Preliminary Acceptance Punchlist
El Paso County – Department of Public Works - Stormwater Section

Project Name:	Rock Top
EDARP Filing Number(s):	PPR1913, CON2218
ESQCP Number:	ESQ2215
Attendees:	DPW SW: Natasha Grimaldo, Ben Jones, and Glenn Reese DPW Development Services: Brad Walters, David Parkerson, and Amanda Rivera Developer: Mitchell Dietrich and Felipe Agustin-Salgado
Date of Walk-Thru:	02/08/2024
Walk-Thru Number:	1 st

Pond [reference sheet numbers 3-6 of the Extended Detention Basin and GEC Plans]:

Project No.:	17066
Date:	8/3/22
Design:	RNW
Drawn:	EAK
Check:	RNW
Revisions:	
1	REVISE RCP SIZE & LENGTH
2	REVISE TRICKLE CHANNEL SLOPES

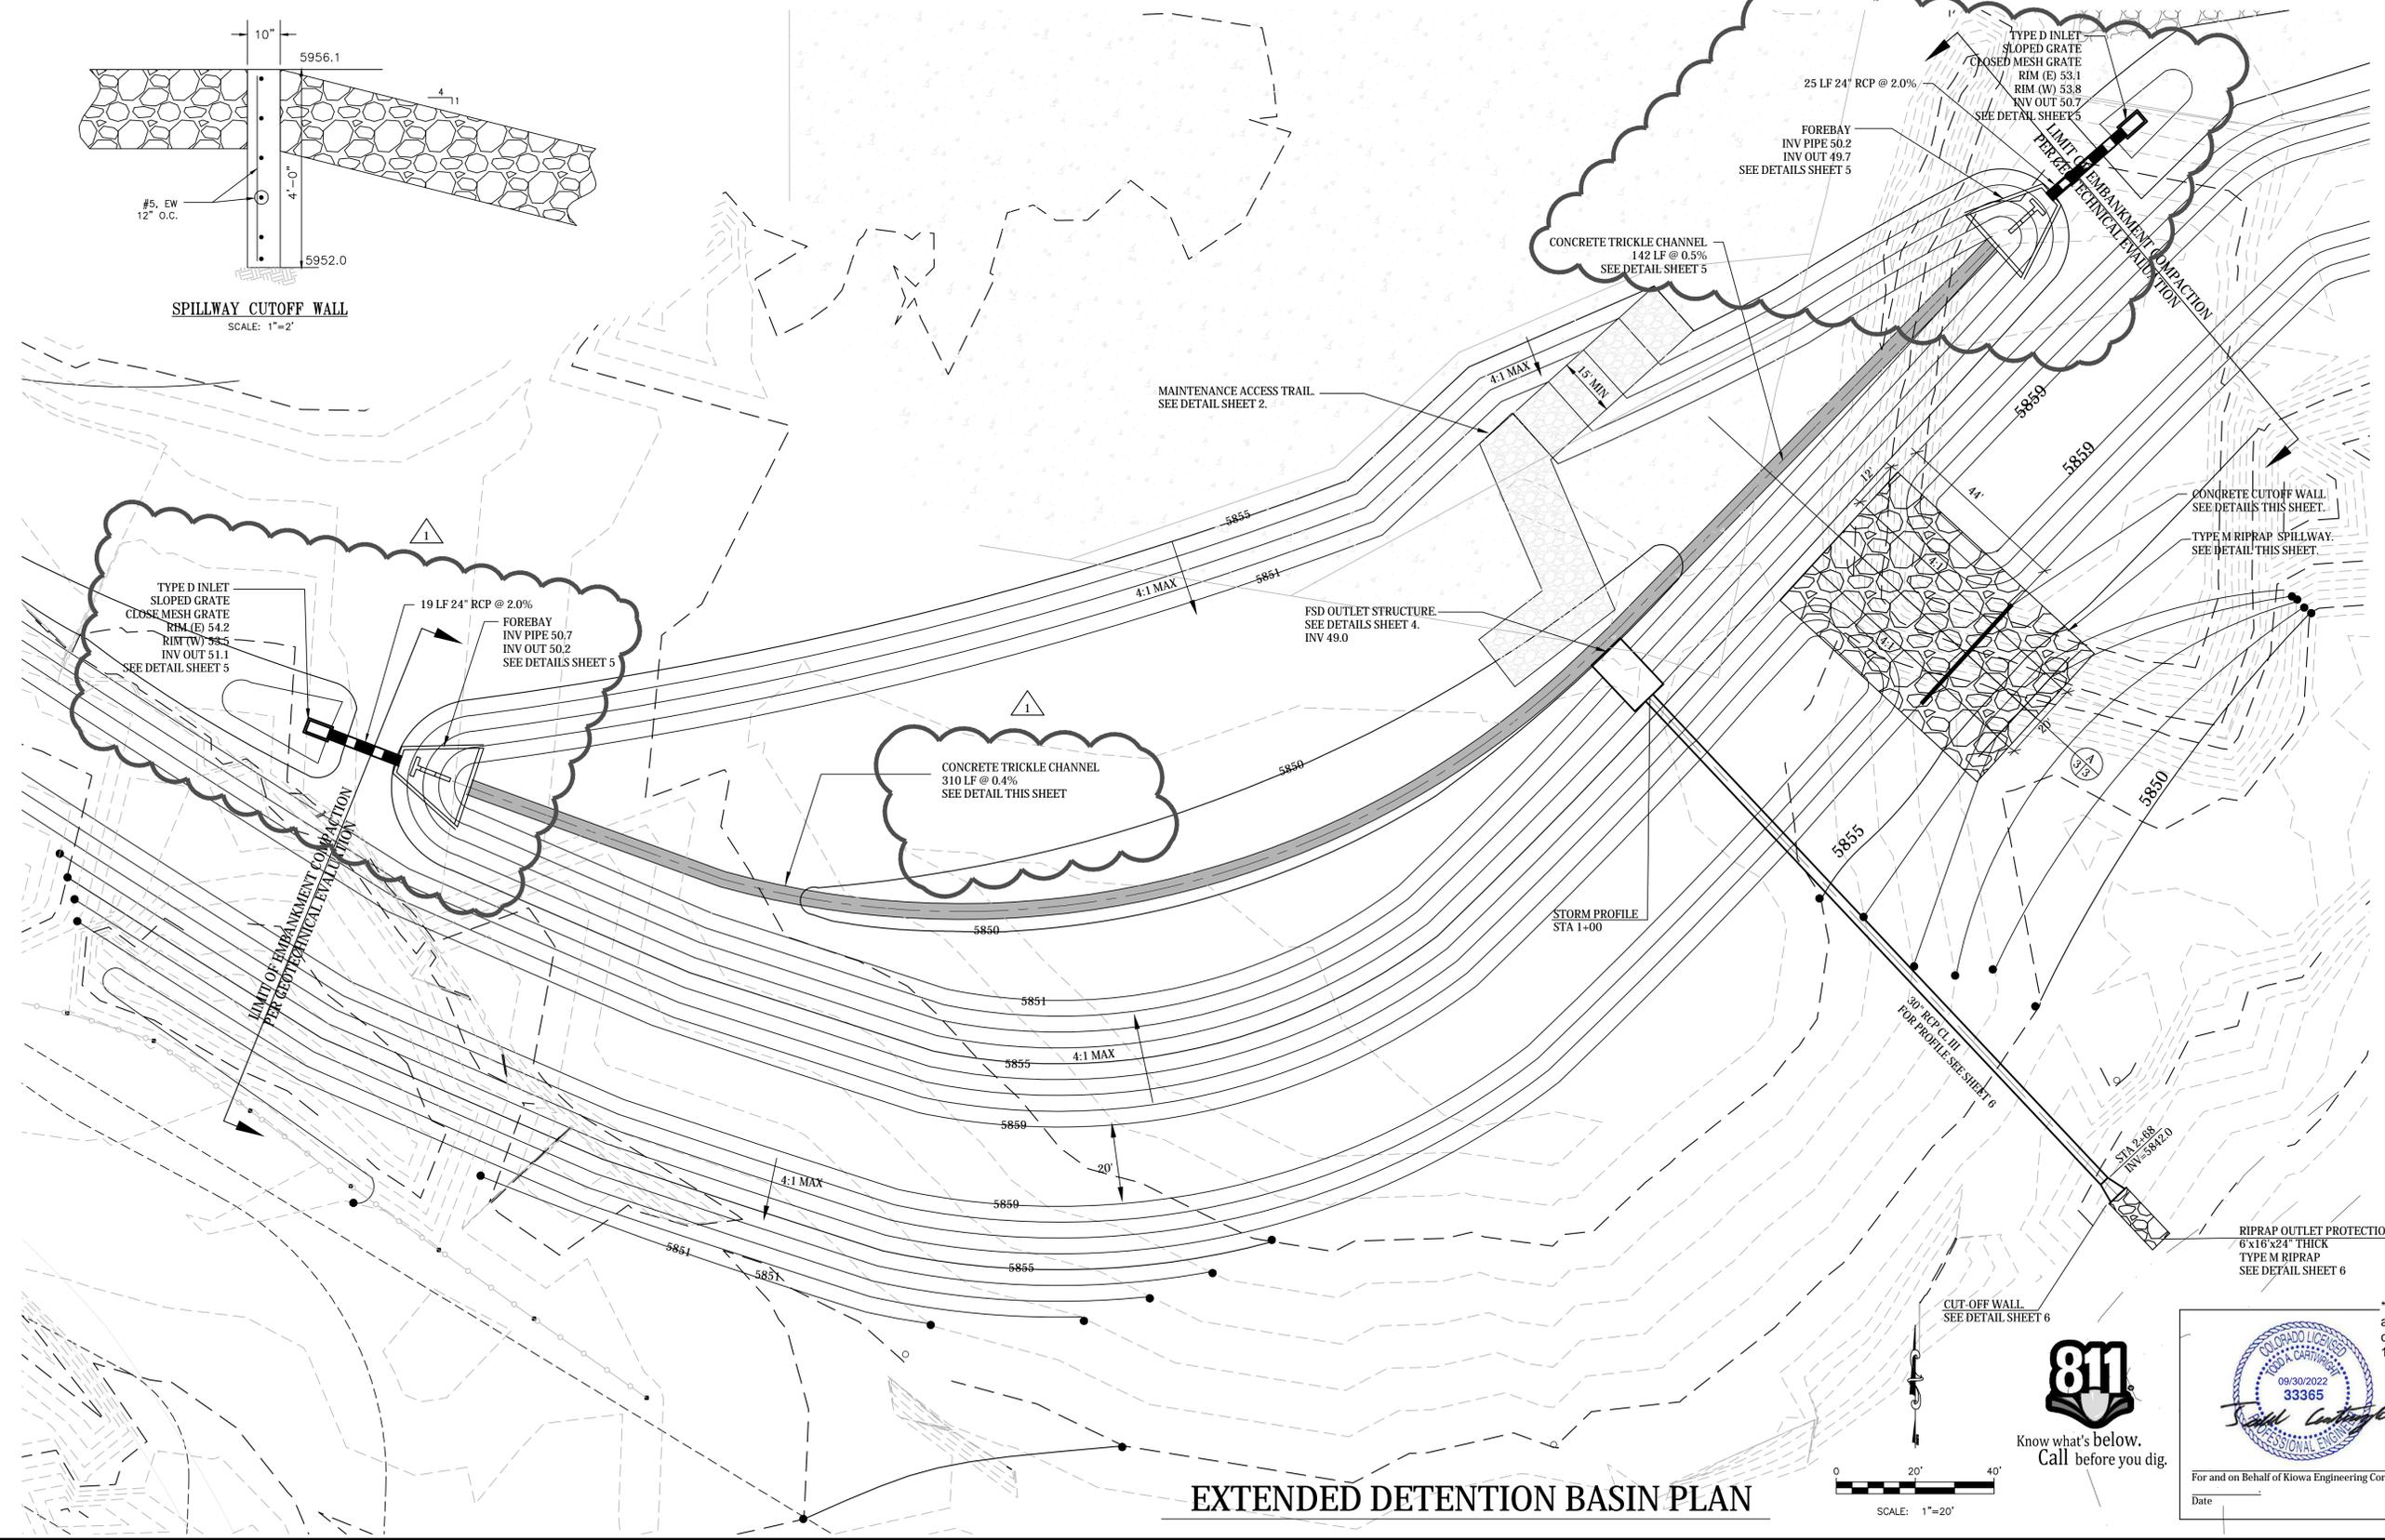
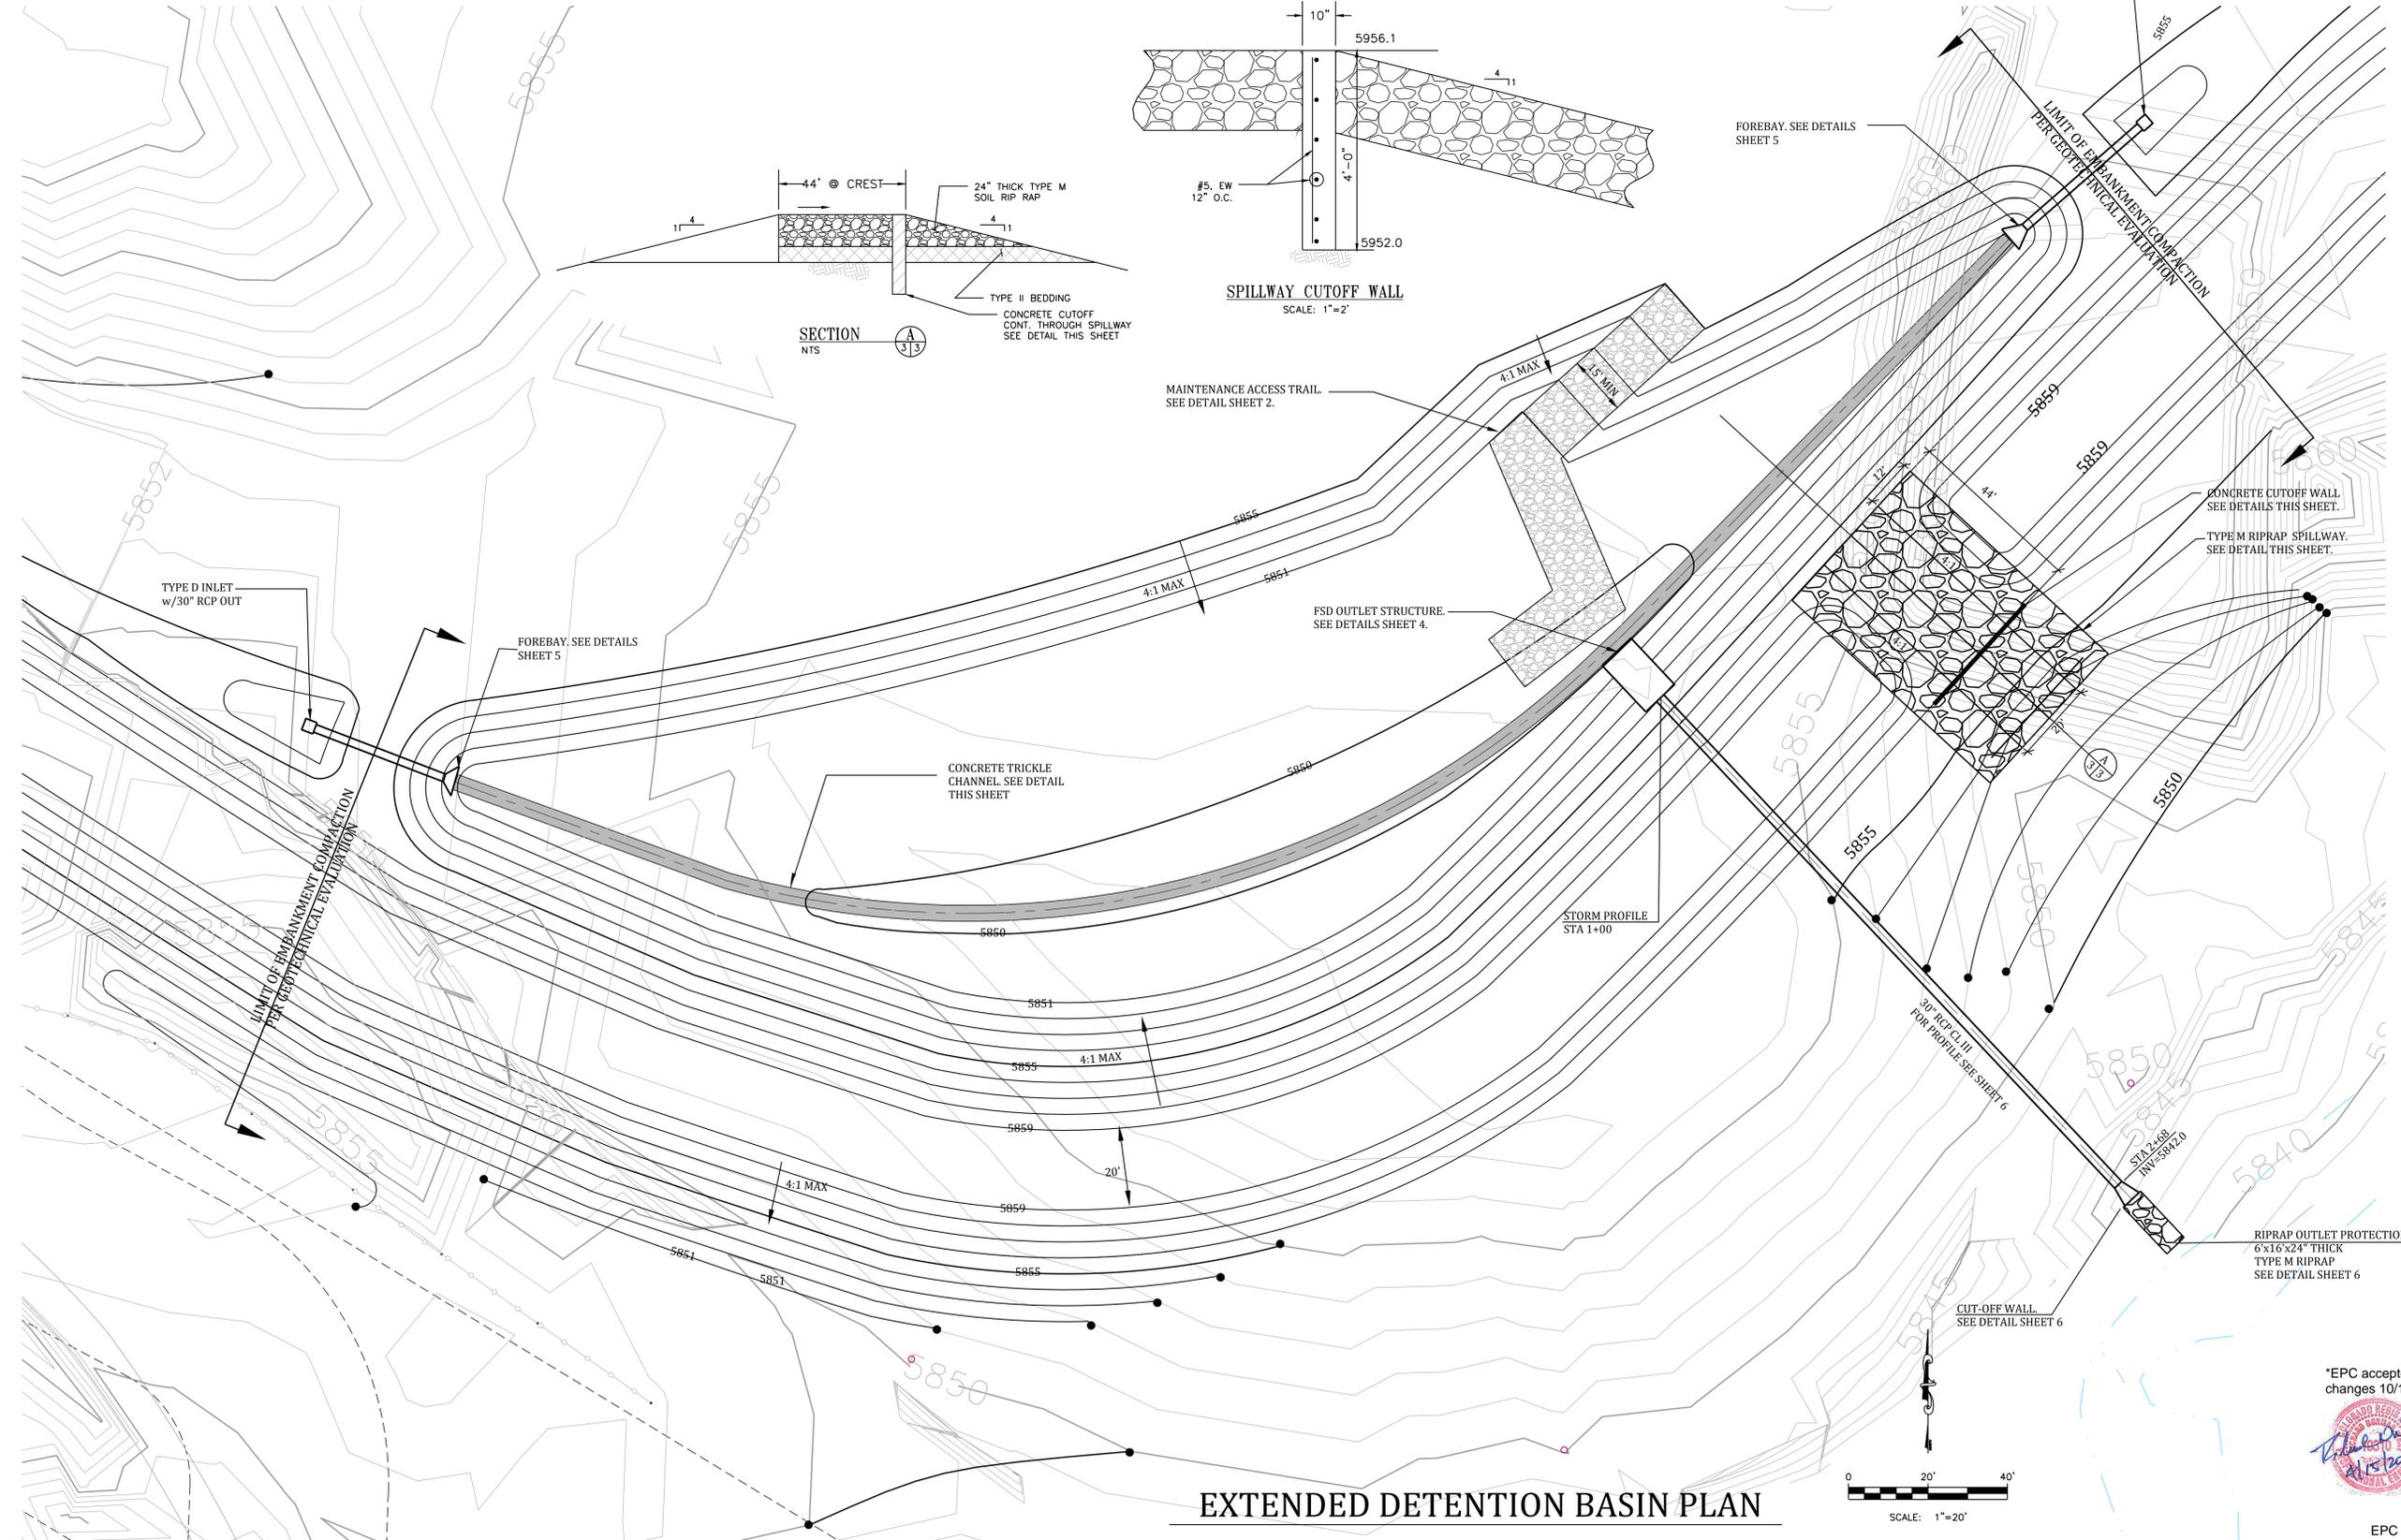
- Grade the bottom of the Spillway to match slope shown on the Extended Detention Basin and GEC Plans. Reference photo 1.
- Clean out sediment and debris from the forebays, outlet structure, and trickle channels. Reference photo 2.

Photo 1: Pond: Grade the bottom of the Spillway to match slope shown on the Extended Detention Basin and GEC Plans. Reference sheet 3.

WEST FOREBAY PLAN
1"=5'

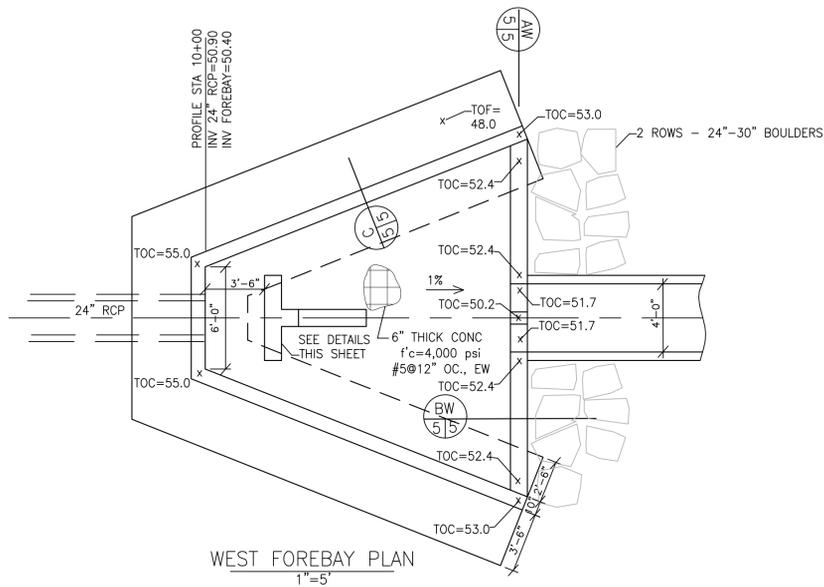
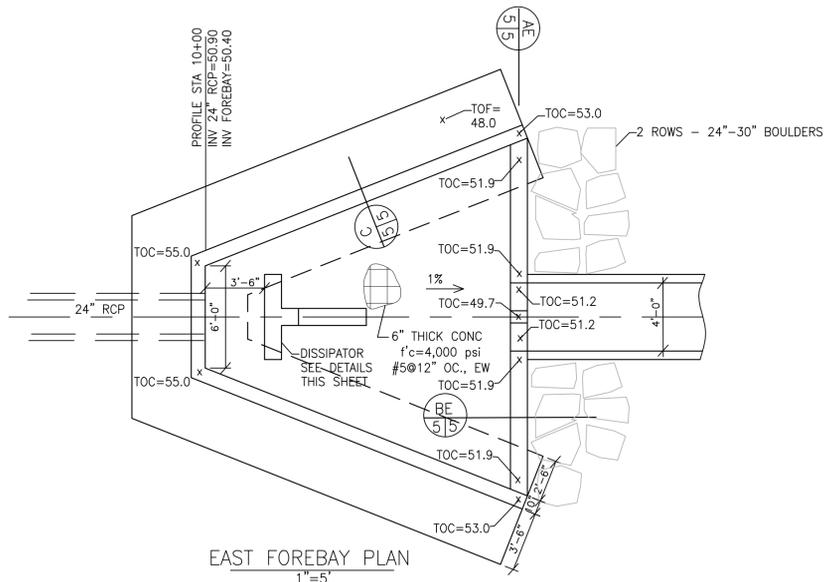
- Flow currently bypasses inlet behind the west forebay. Regrade per plan to promote flow into type D inlet. Reference photo 3.
- Flow currently bypasses inlet behind the east forebay. Regrade per plan to promote flow into type D inlet. Reference photo 4.

Photo 3: Flow currently bypasses inlet behind the west forebay. Regrade to promote flow into type D inlet.

Photo 4: Flow currently bypasses inlet behind the east forebay. Regrade to promote flow into type D inlet.
